**Re: Objection to MP08_0244 MOD 1 Modification Request for Mixed Used Development at 23-37
Lindfield Avenue and 11 Havilah Lane, Lindfield**

PCU041615

1 HAVILAH LA ELEVATION
2001 SCALE1 : 250

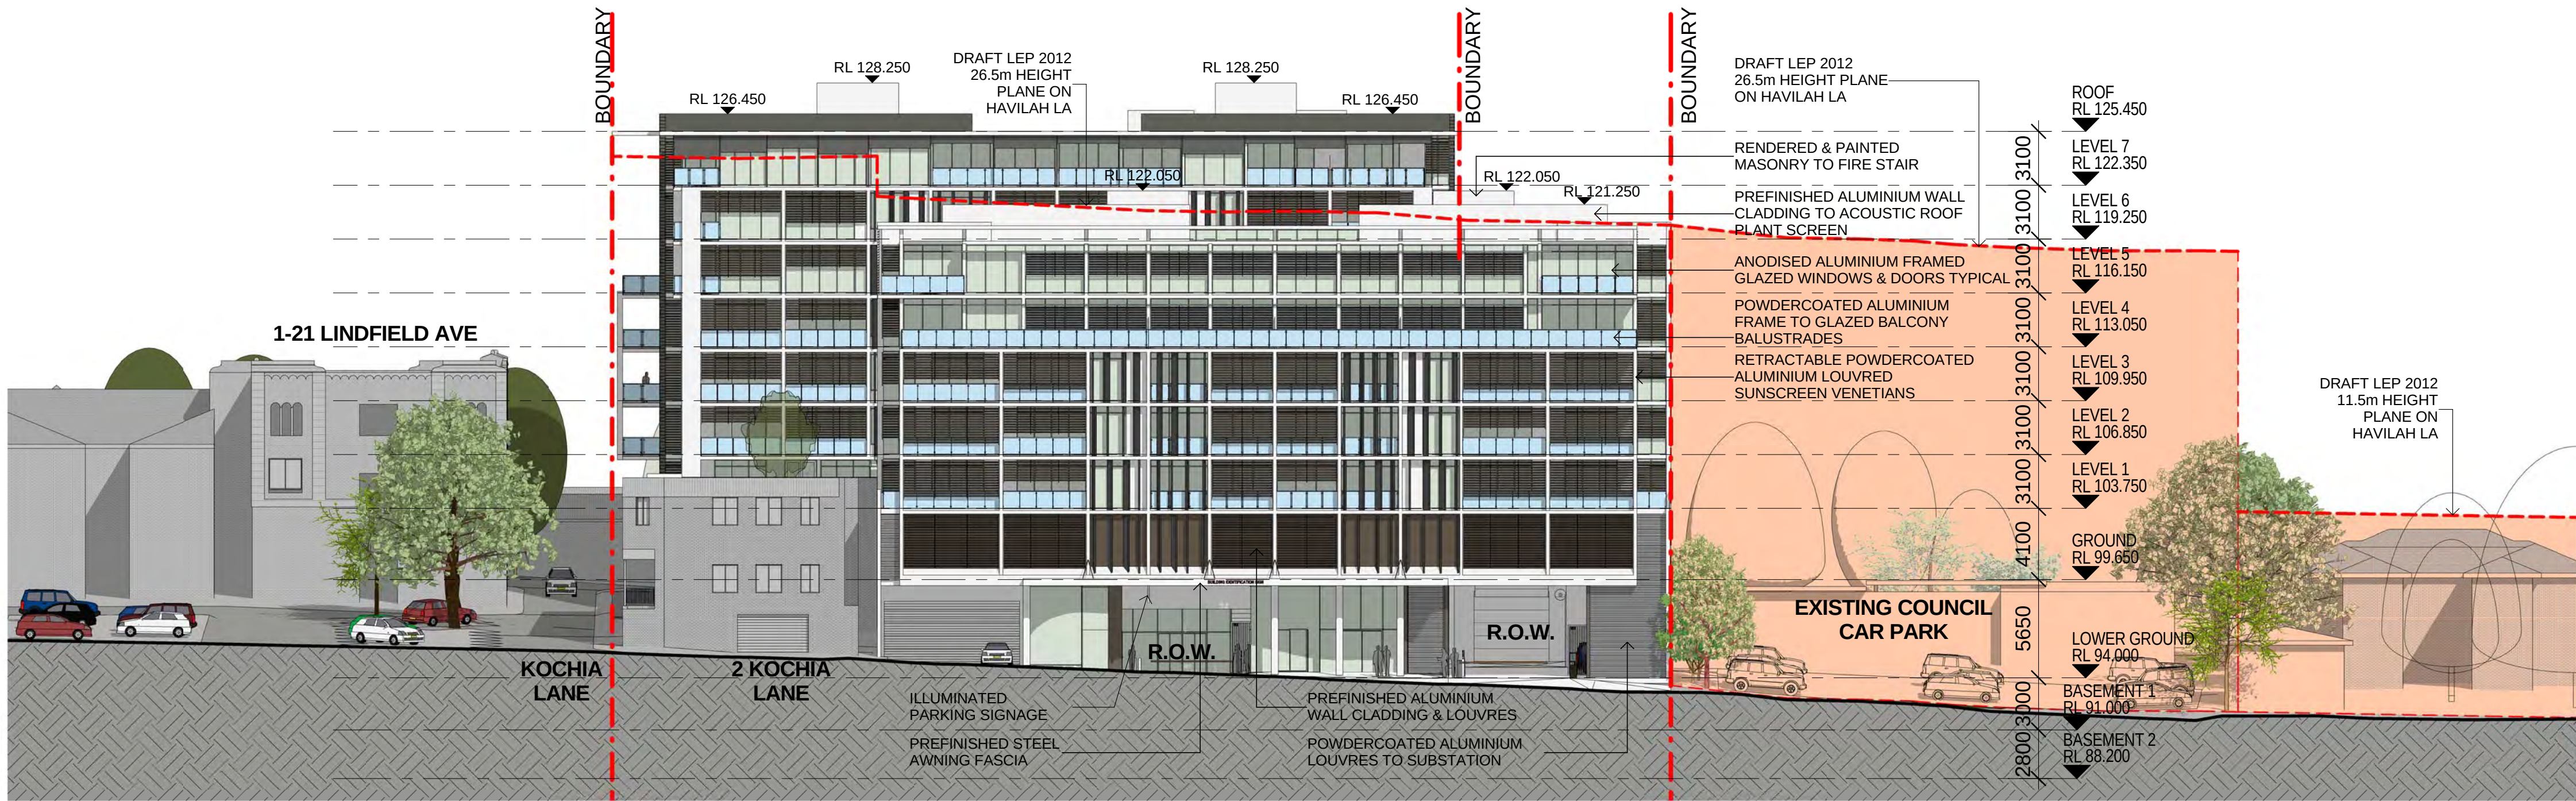
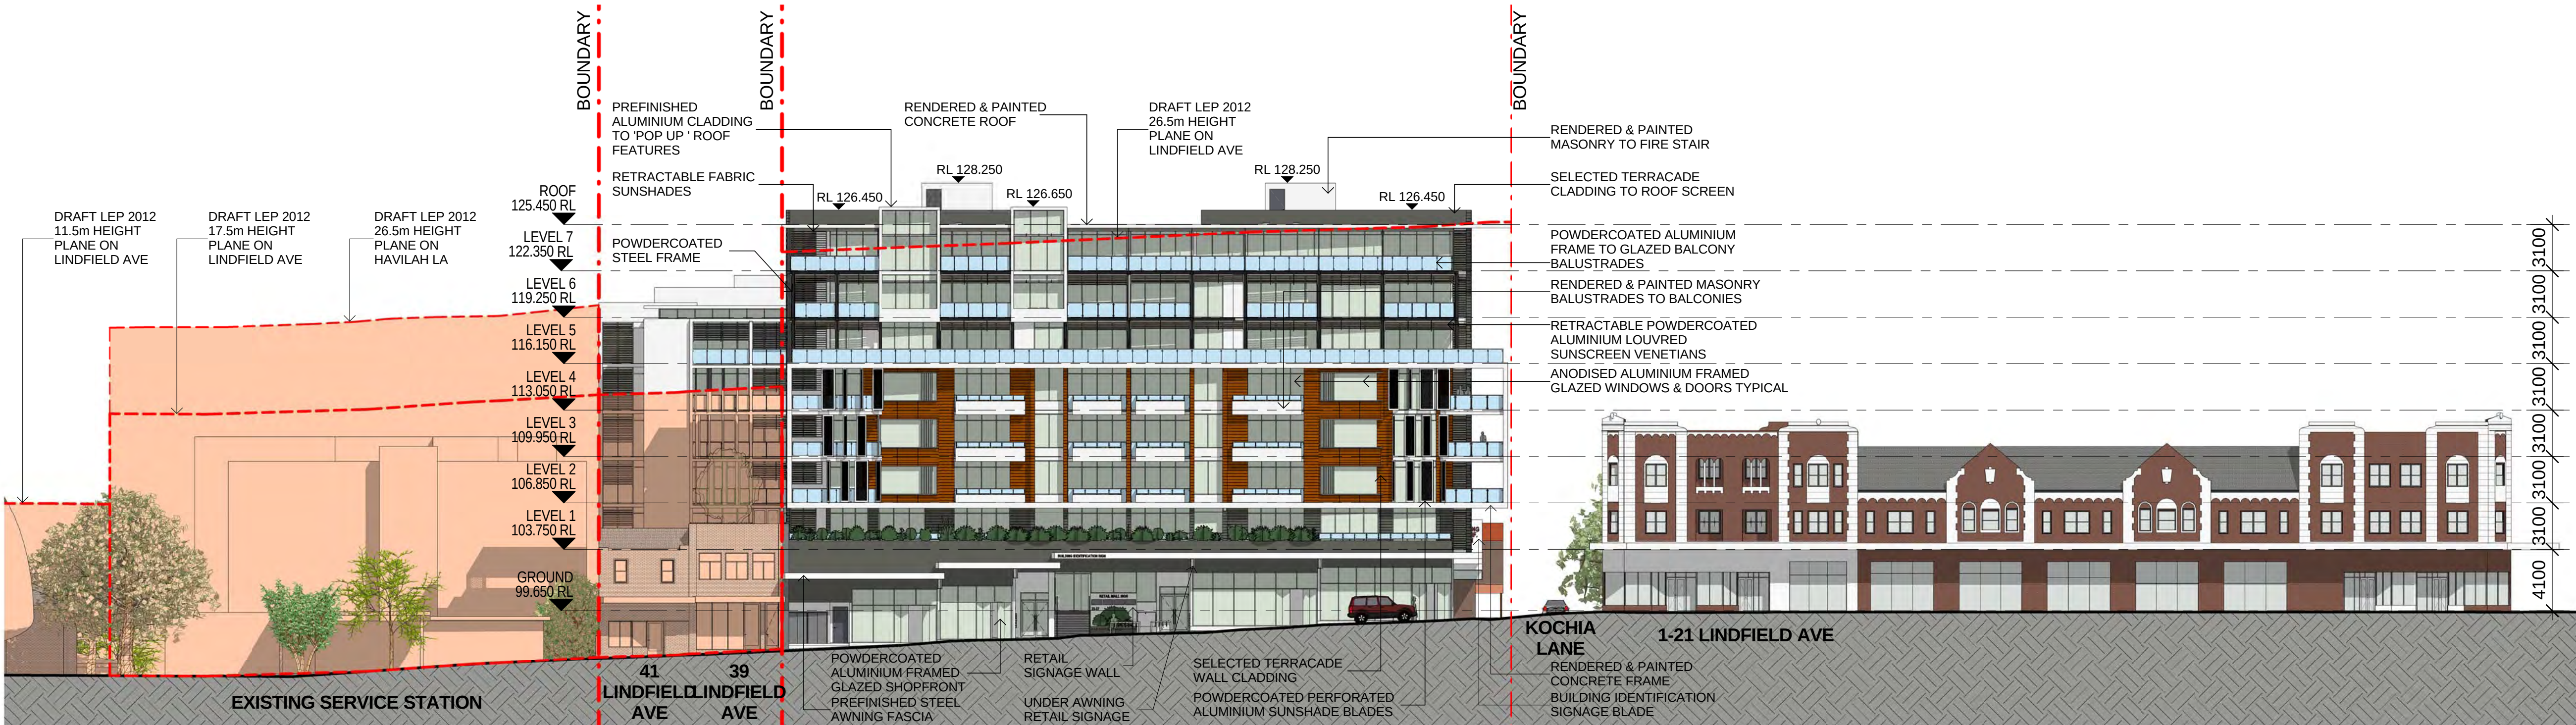
- The increase of an additional storey to both buildings: 8 storeys on Lindfield Avenue and 7 storeys on Havilah Lane creates excessive height and bulk and is out of character with the surrounding buildings, including the heritage listed adjacent building on Lindfield Avenue

- The additional storey (combined with less set back than the approved design) on Havilah Lane now creates privacy concerns for over 40 apartments in the adjacent 8 Havilah Lane, 8 Kochia Lane and 2-8 Milray Street residences
